**Re: Starbucks at 1440 Coors Blvd NW
Erosion and Sediment Control Plan
Engineer's Stamp Date 11/09/2022 (G11E069)**

Based upon the information provided in your submittal received on 11/15/2022, the above referenced ESC Plan cannot be approved until the following comments are addressed.

C101

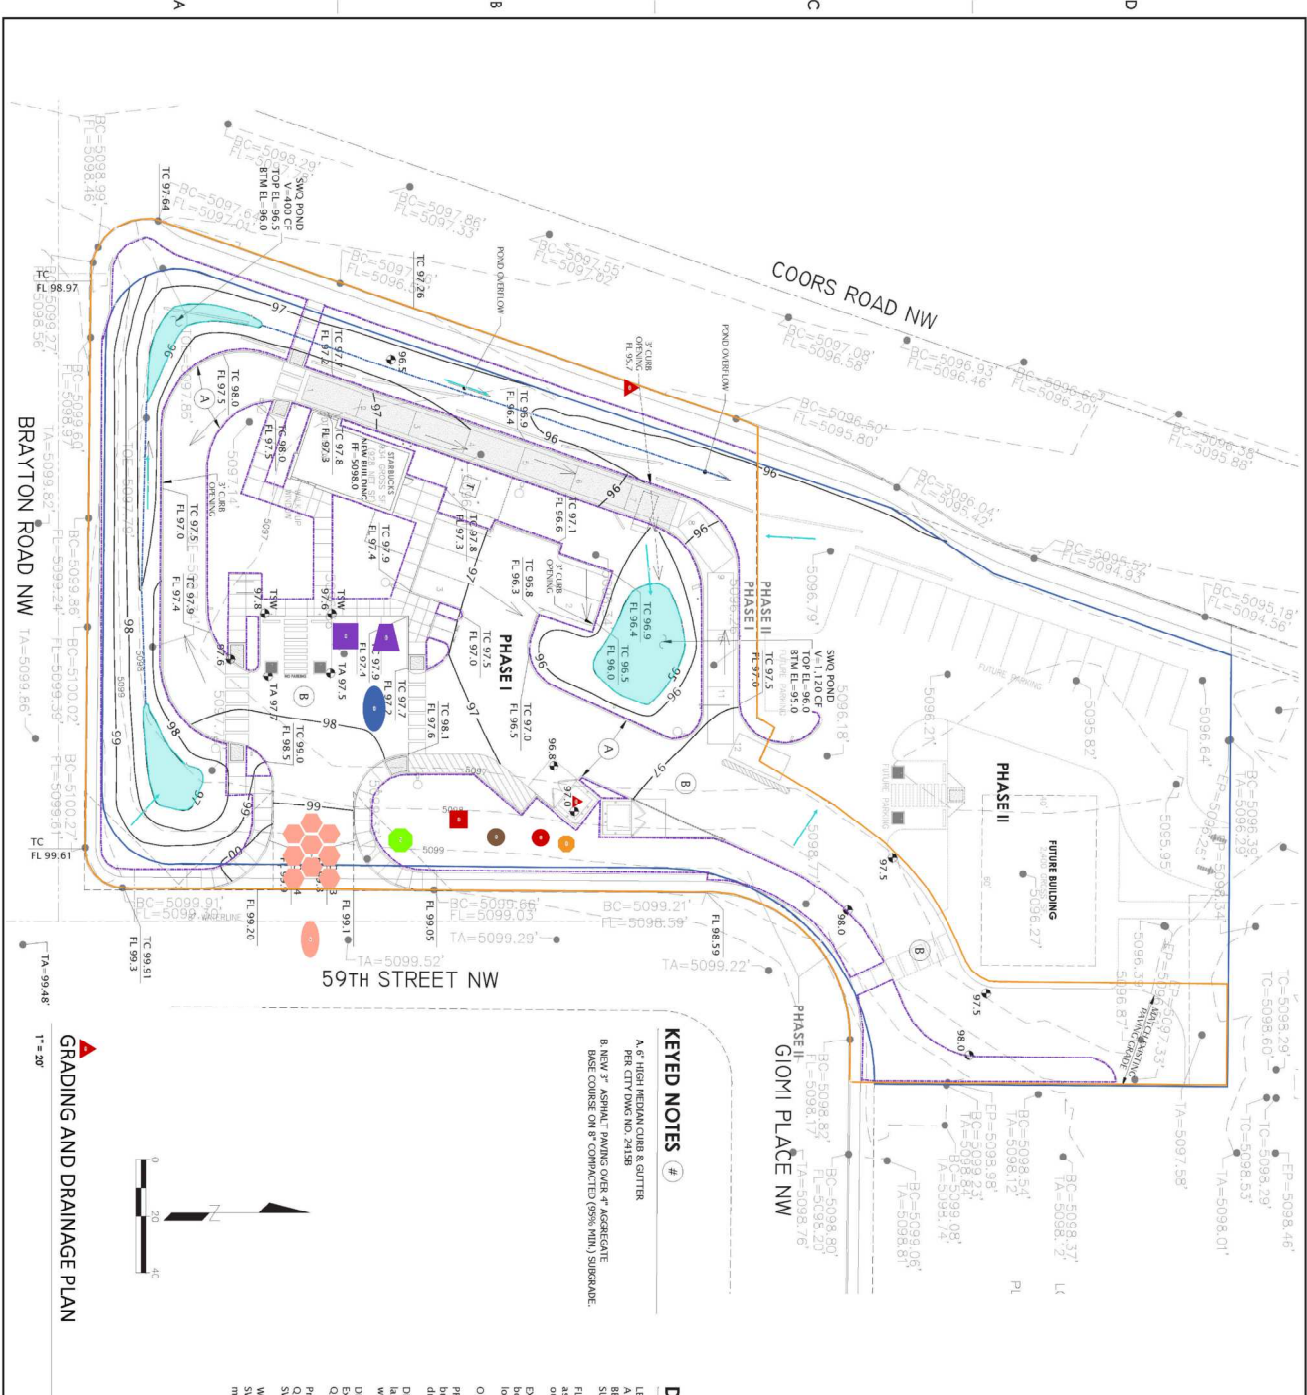
3. The limits of disturbance must include all existing areas of land disturbance. Expand the limits to include Phase 2 since it is already disturbed. (CGP7.2.4.b.i);

5. Cutback swales are generally not applicable for commercial sites. The perimeter controls need to be silt fence all of the way around the disturbed area to control access and prevent sediment from leaving this site on the east and south sides of the site where sediment in the street has already been a problem.

**L200**

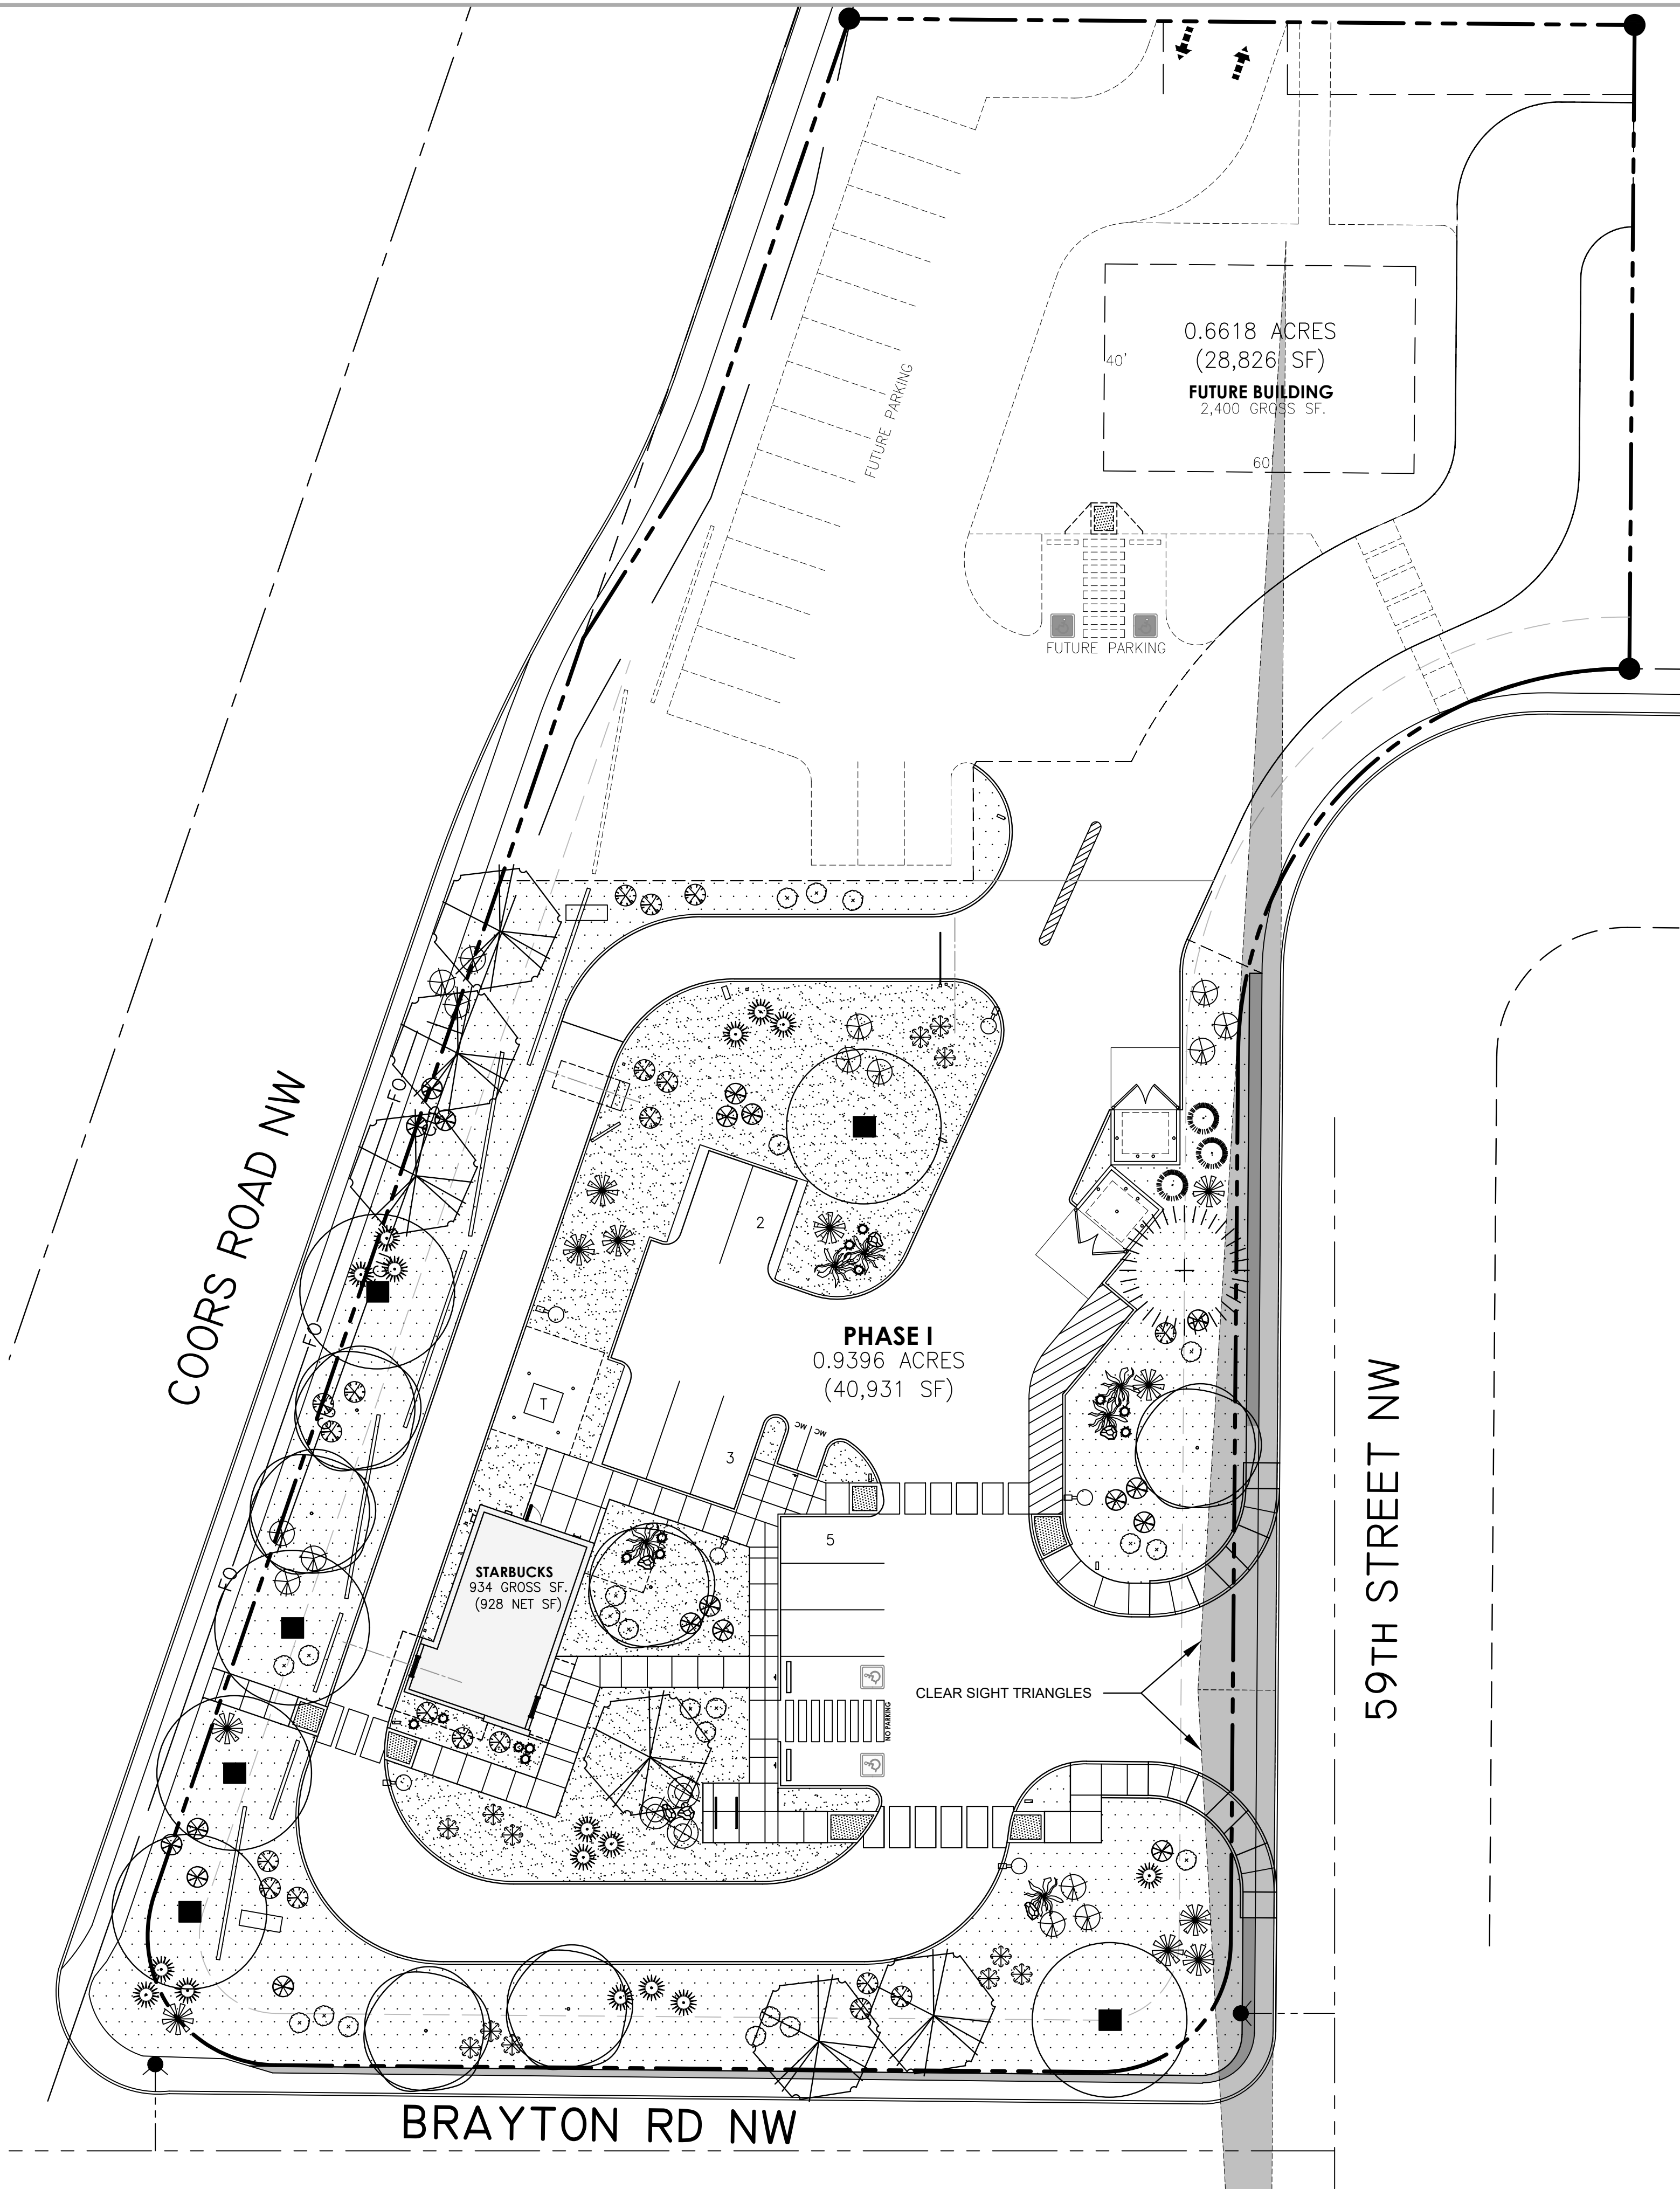
6. The SWPPP must include site-specific interim and permanent stabilization per CGP 9.4.1.c.i. The Landscape Plan can be used to satisfy this requirement and should be

submitted separate from the ESC Plan with the application to the Stormwater Quality Section of the Planning Department and it should be included in the SWPPP. Provide a specification on the ESC Plan for any disturbed areas not covered by the Landscape Plan.
